Tween Bridge Solar Farm

9.9 Statement of Common Ground with Natural England

Document Reference: 9.9

Revision **12**

Figure 2: Non Breeding Bird Mitigation Plan – No Annotation

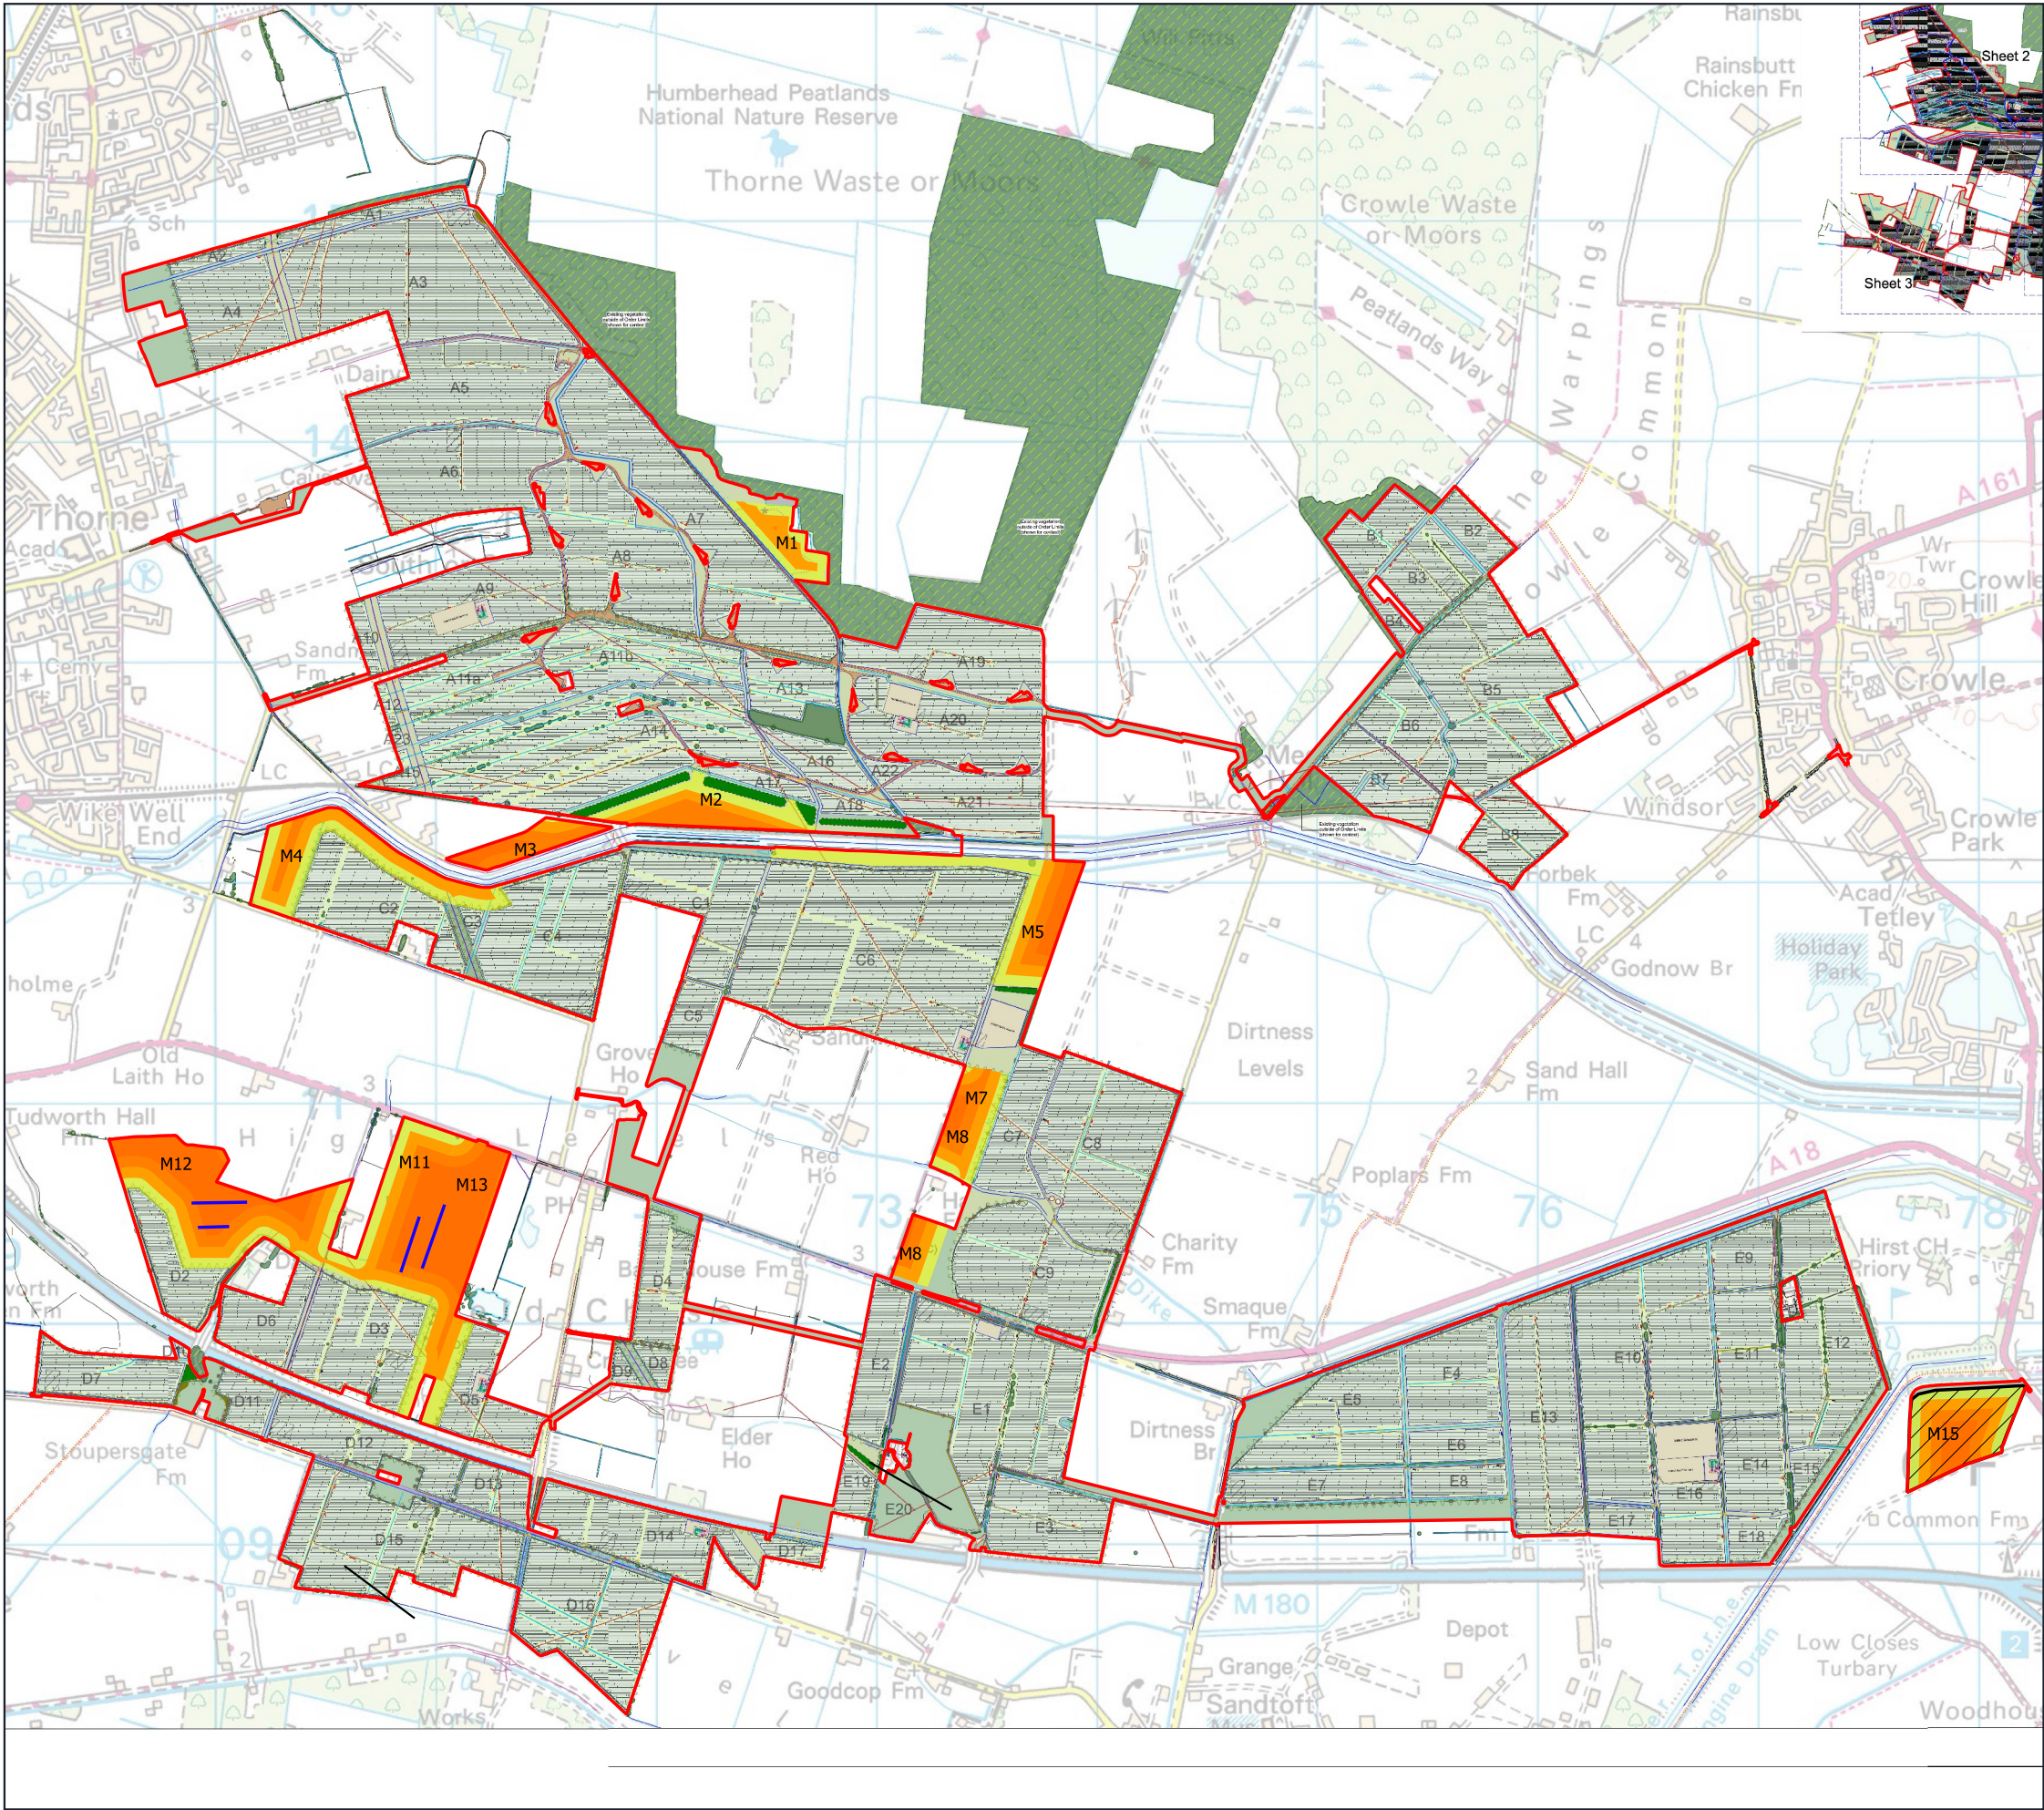
NE1	<p>International designated sites</p> <p>Humber Estuary SPA</p> <p>Humber Estuary Ramsar</p>	<p>Potential loss of functionally linked land (FLL) for the relevant qualifying bird</p> <p><u>Design of the mitigation areas</u></p> <p>Natural England concurs with point 6.2.36 of the sHRA, which concludes that for greylag geese, lapwing, mallard, and pink-footed geese the site is functionally linked to the Humber Estuary SPA and</p>	<p>The Applicant has developed mitigation to ensure that suitable habitat is maintained for all of these species, with measures incorporated into the scheme design to avoid loss of ecological function associated with FLL supporting SPA bird species.</p> <p>In addition, the Applicant notes that the Order Limits are not functionally linked for golden plover and that</p>	Under Discussion

<p>mitigation should be provided. We welcome that the proposed mitigation will also deliver for golden plover, which have been recorded in high numbers within the Wider Survey Area.</p> <p>features of the listed SPA/Ramsar sites – Core mitigation areas and the implementation of a buffer (C) and (O)</p> <p>Natural England note the description of the habitat baseline for the mitigation areas provided in point 2.14 (Table 3) of the Non-Breeding Bird Mitigation Strategy. We advise that an assessment of each parcel should be provided. This should detail proposed design and enhancement/management (in line with the below advice in NE2) and demonstrate how the habitat suitability and capacity of each parcel will deliver for the intended species.</p> <p>We acknowledge that the Bird Days calculations have been provided, though advise that while they are a useful tool for informing approximate mitigation area size, they should be used in conjunction with ecological knowledge</p>	<p>greylag geese are not an SPA qualifying species, although consideration has been given to these species within the mitigation design.</p> <p>The Planning Inspectorate’s Section 51 letter (ENO10148, dated 15 August 2025) states that greylag geese are not an SPA qualifying species and that it was not clear why this species was being included within the Report to Inform Habitat Regulations Assessment [Document Reference 5.3 Revision 4]. As such, whilst this species has been considered within the mitigation design as part of a robust approach, mitigation for greylag geese is not required.</p> <p>The Applicant confirms that a full assessment of each parcel has been provided, and includes details on the proposals and management of each parcel. Environmental Statement Appendix 7.10 Non-Breeding Bird Mitigation Strategy [Document Reference 6.3.7.10 Revision 2 REP1-019] is produced and submitted at Deadline 1 in this regard.</p>

<p>of the carrying capacity of different habitat types.</p> <p>For information, we highlight that golden plover and lapwing rely on open vistas to forage, and the relevant mitigation areas should seek to deliver this site characteristic to ensure suitability for these species. Golden plover tend not to use fields less than 10ha, and fields 15–30ha or larger are used more often especially when in flocks of over 100 birds².</p> <p>We advise that existing habitat suitability should be factored into the assessment of the proposed mitigation areas. We recommend that the design of mitigation areas should take into account potential benefits of securing areas of higher existing bird usage as mitigation areas through enhancement, rather than the establishment of entirely new habitats which have a lower usage baseline. For example, the <i>Wintering Bird Survey Results – 2023 to 2024 (Lapwing)</i> show significant lapwing usage of the southernmost point of the site in both years of surveys.</p>	<p>The Applicant confirms that Bird Days calculations have been used as a tool to inform the approximate mitigation area required, alongside ecological knowledge of the carrying capacity of different habitat types. Further detail is provided within the Report to Inform Habitat Regulations Assessment [Document Reference 5.3 Revision 4] updated at Deadline 2.</p> <p>Surveys undertaken demonstrate that golden plover are not a functionally linked species and therefore no species-specific mitigation is required. However, the mitigation areas have been designed to provide open vistas suitable for lapwing, which will also provide suitable habitat for golden plover.</p> <p>Section 2 of the Non-Breeding Bird Mitigation Strategy submitted as Environmental Statement Appendix 7.10 Non-Breeding Bird Mitigation Strategy [Document Reference 6.3.7.10 Revision 2 REP1-019] sets out calculations of land availability with 150 m open vistas, with this information also included within the</p>

<p><u>Has the removal of the M1 parcel has been factored in to the total?</u></p> <p><u>If M1 is the area to be removed from the mitigation strategy - it must be</u></p>	<p>to reflect bird use where possible. Given the mobility of SPA bird species, and the location of the Order Limits approximately 7.7 km from the Humber Estuary SPA, birds will utilise suitable habitat across a large area. This is supported by non-breeding bird survey results that show use of the Order Limits changed between the survey periods, although also show notable lapwing use in the northern part of the Order Limits close to proposed mitigation areas.</p> <p><u>The Applicant confirms that the parcel M1 is not proposed to be removed, rather it is proposed to be reduced in extent and would therefore continue to perform a mitigation function for breeding and non-breeding birds. Nonetheless, as detailed in Table 1-1: Non-Breeding Bird Mitigation Land Calculations at the end of this document, the mitigation calculations do not include parcel M1 due to its proximity to wind turbines</u></p>

<p><u>demonstrated how this will be accounted for.</u></p> <p><u>Could clarification be provide as to whether this is in addition to the above 43.67ha? Aware this will likely be set out further in the mitigation strategy</u></p> <p><u>We confirm this remains under discussion - We acknowledge further details of the proposed approach but as discussed in call on 24 February - we will need to see the updated mitigation strategy accounting for suggested changes and demonstrating in full the carrying capacity</u></p>	<p><u>The Applicant confirms that as seen in Table 1-1: Non-Breeding Bird Mitigation Land Calculations at the end of this document, that the calculations do not include parcel M1 and the figures provided demonstrate there is sufficient mitigation land, based on using Bird Days calculations and the habitat requirements and ecological knowledge of the species being mitigation.</u></p> <p><u>The Applicant confirms that 108.84ha is in addition to 43.67ha.</u></p> <p><u>As detailed in Table 1-1: Non-Breeding Bird Mitigation Land Calculations at the end of this document, and shown in Figure 1: 16413_P16a_600m Buffers_TLR_RR, at the end of this document.</u></p> <p><u>The Applicant confirms that reducing in extent parcel M1 would not affect the mitigation strategy and that sufficient mitigation is provided</u></p>

<p>Report to Inform Habitat Regulations Assessment [Document Reference 5.3 Revision 4] and provided as part of Figure 1 within this document.</p> <p>Several mitigation parcels larger than 10ha with at least 150 m open vistas are provided, including M12 and M13.</p> <p>A total of 43.67ha of mitigation land with 150 m open vistas is located beyond 600 m of wind turbines, in line with point NE3 (see below), and is available for lapwing. Bird Days calculations demonstrate that 24.99 ha is required for lapwing (Appendix 2 of the Report to Inform Habitat Regulations Assessment [Document Reference 5.3 Revision 4]), confirming that more mitigation land is provided than required. Additional mitigation land within 600 m of turbines, including parcels M1 and M2, is also available, and lapwing have been recorded using these areas, therefore ensuring that additional land is available for this species.</p> <p>When considering mitigation land beyond 600 m of turbines_108.84ha</p>

<p>remains available for pink-footed geese and mallard, the remaining functionally linked species recorded within the Order Limits, <u>even when accounting for the 43.67ha provided for lapwing</u>. Bird Days calculations indicate that 22.98 ha is required for pink-footed geese, and as this species forages in similar habitats to lapwing without competing for the same resources, more than sufficient land is provided.</p> <p>Bird Days calculations are not applicable to mallard, as detailed in the <u>Report to Inform Habitat Regulations Assessment [Document Reference 5.3 Revision 4]</u>. However, substantial mitigation land remains available beyond 600 m of turbines even after accounting for lapwing and pink-footed geese (85.86 ha), in addition to enhancements to the ditch network which will improve habitat suitability for this species.</p> <p>Table 1.1 provides further detail on the mitigation land calculations.</p> <p>The Applicant confirms that mitigation areas have been selected</p>
